Our Ref: P/2/19/PL

Variation of condition 2 imposed under P/107/16/PL relating to approved plans.

7 Webb Close Pagham

Thank you for your internet representation made on 11th February 2019 which has been recorded as '**an objection**' with the comments as follows:

PROPOSED PLANS

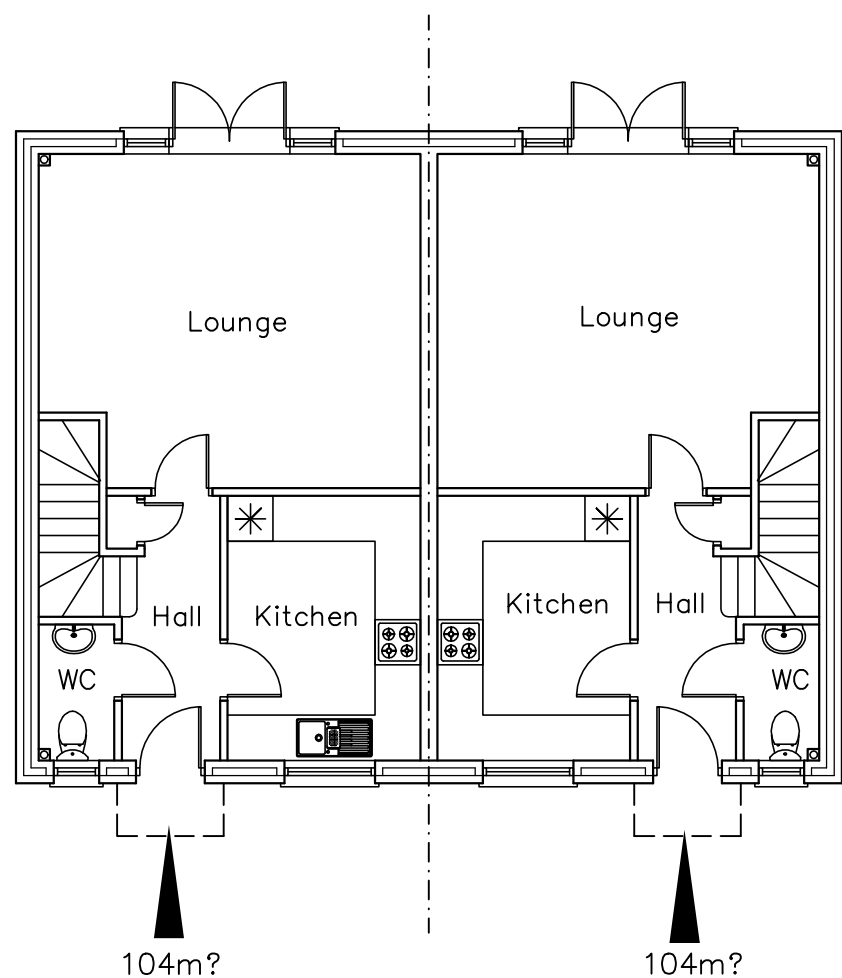
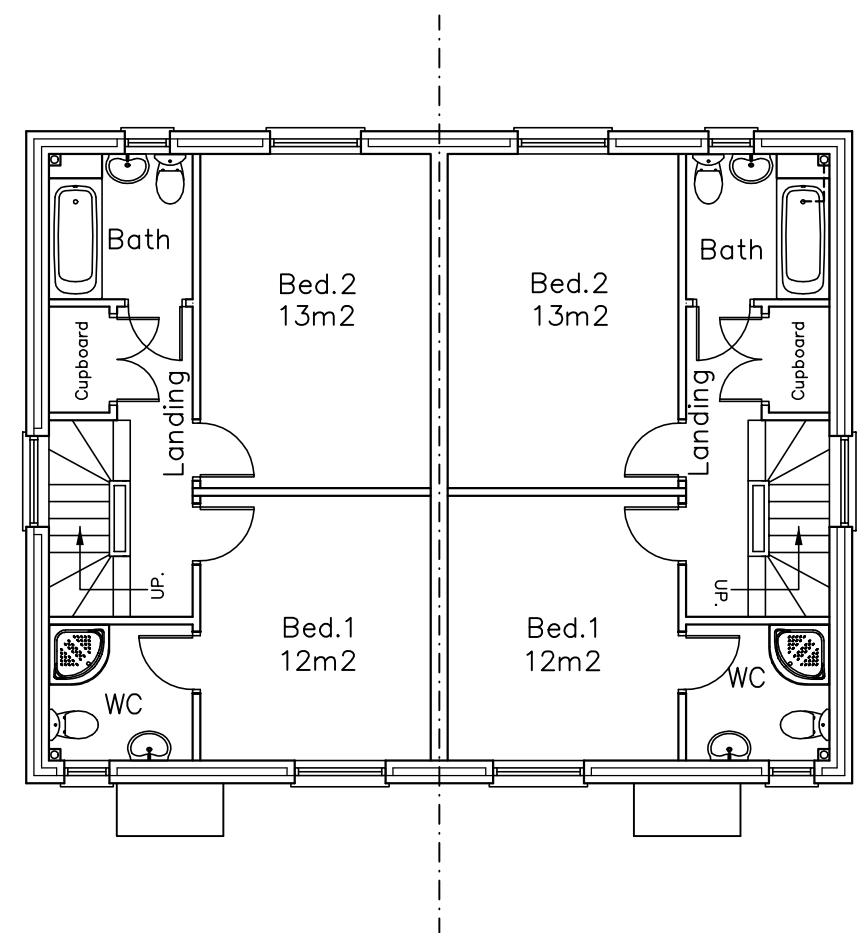
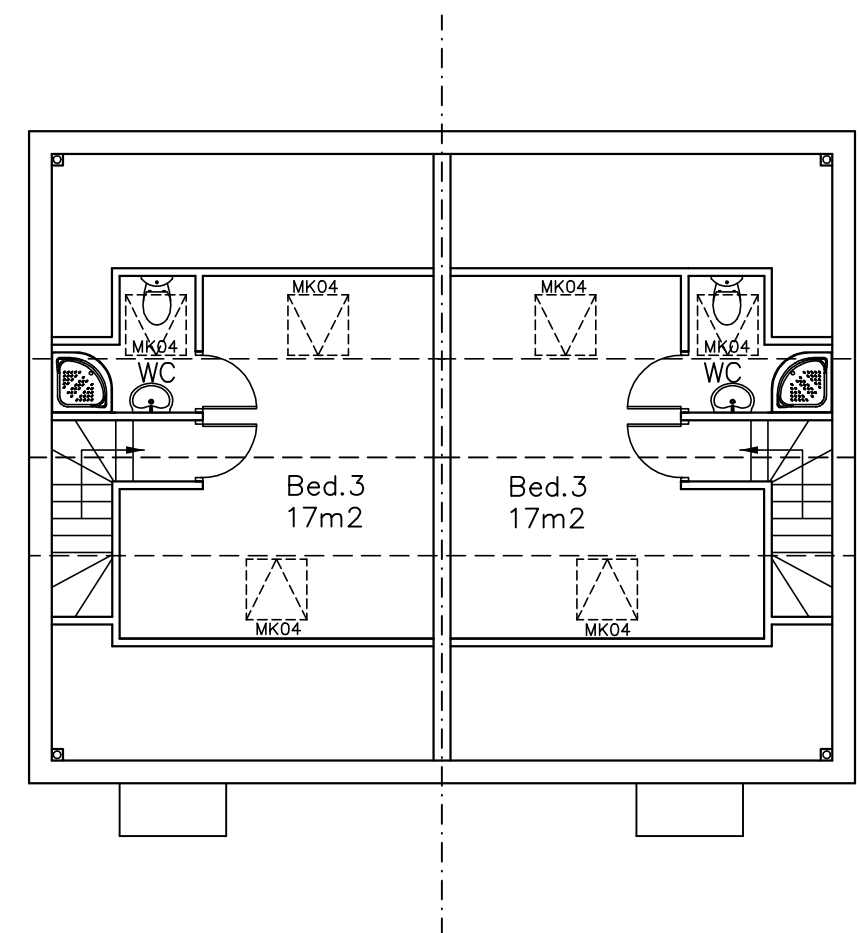
Having spoken to the builders on site 07/12/2018, I was advised that a 3rd bedroom was being constructed in the roof space together with an ensuite, hence the installation of velux windows. When was the decision made to change the plans from 2 x 2 bedroomed semi-detached houses to 2 x 3 bedroomed semi-detached houses?

1. I am concerned that my privacy will be even more invaded; the new houses will have a direct view through my small bedroom window at the back of the house to the front.

PROPOSED ELEVATIONS

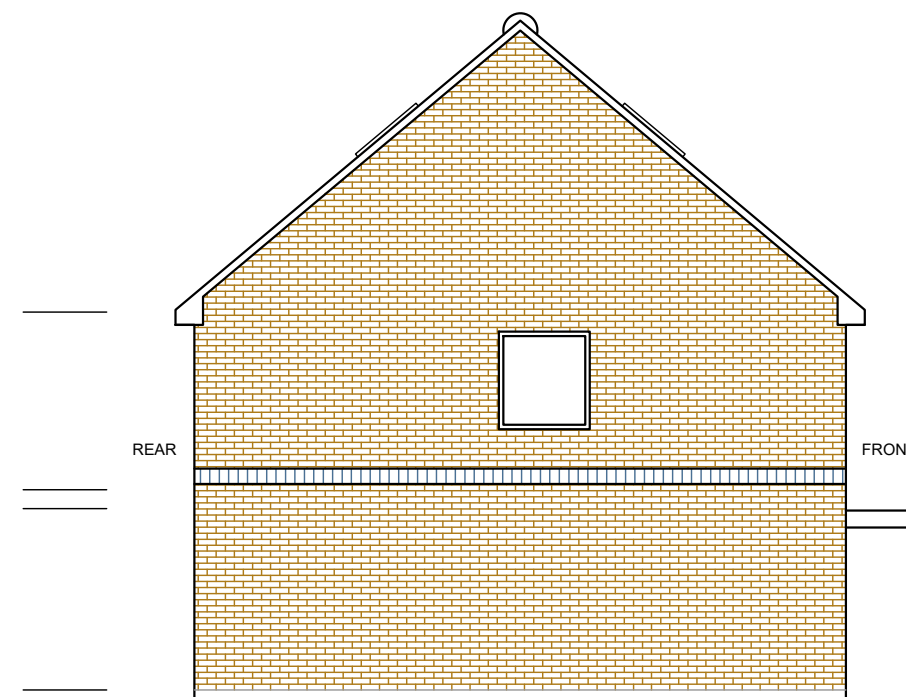
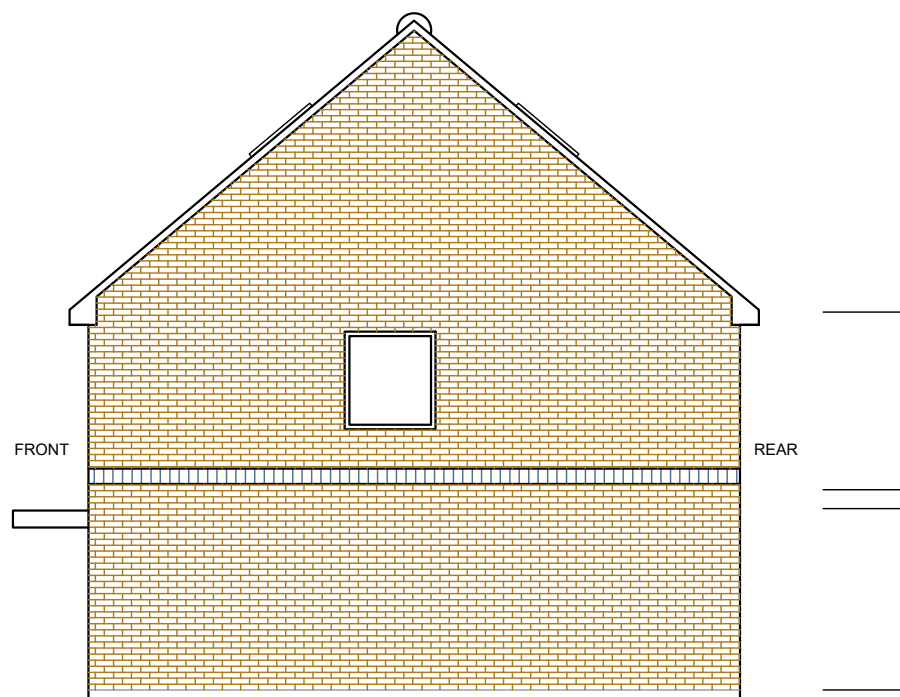
Roof construction started 20/11/2018. I have photographs which clearly show the provision of 2 x velux windows in the roof at the front of the house and provision for 1 x velux window at the rear, which is the opposite to the submitted plans under P/2/19/PL.

4. I believe noise will also be an issue, especially in the summer months when the velux windows will be open.

5. The plans indicated an opaqued window to the side of the new houses particularly facing Mulberry Court. I see that this window, as fitted, opens which removes the privacy that would have been provided by a fixed window.
